From: [Paul Jenks DOM](#)
To: [Jared Romero](#)
Cc: [John Heuertz](#); tchen@cabq.gov
Subject: Re: Hahn Arroyo
Date: Monday, March 11, 2024 6:06:22 PM
Attachments: [image001.png](#)

Thanks for reaching out. AMAFCA does not have any issue with the vacation of the alley as long as the portion of AMAFCA property where a small portion of the parking lot is located is striped to not allow parking. The concern with the vacation of the alley so that it can be purchased is that AMAFCA would no longer have the right to access the area if it is private property (without an easement being dedicated to AMAFCA for access).

Good morning Jared, Mr Chen from the City told me to contact you regarding our request to vacate and purchase the alley behind our office complex. We have no plans to interfere with the alley on the south of the building that is adjacent to the alley. There is already a service access road there that allows access to the houses along the arroyo there. Please let me know what you might need from us so that we can move forward. I cc'd my business partner so that he can be in the loop. Thanks for your time.

AMAFCA

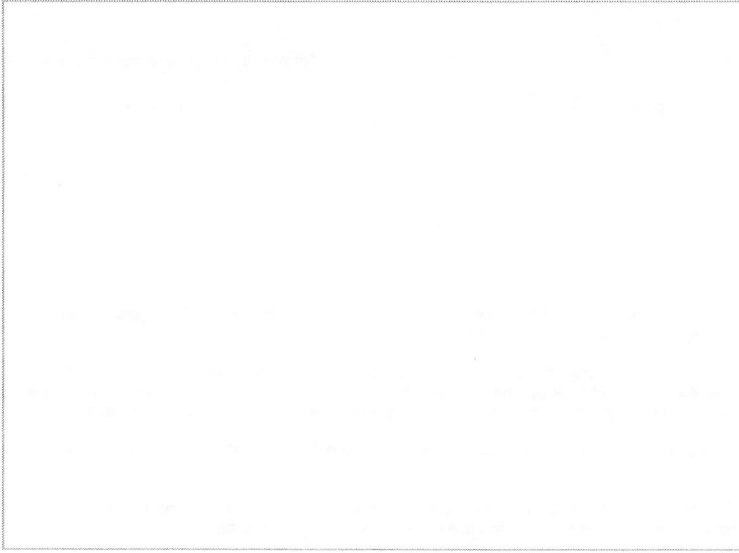
The area below in yellow is AMAFCA property, and in the event that a vehicle is parked in the last parking spot, AMAFCA would not be able to access our facility from this area; the alley provides a location for secondary access if needed. The required striping would keep vehicles from parking here and we could move forward with the vacation of the alley.

Yes, I've spoken to my Maintenance Superintendent and would be acceptable to AMAFCA.

When we had the parking lot resurfaced 3 years ago, we had that space designated as a NO PARKING.

We would be happy to have the area you indicated repainted fresh.
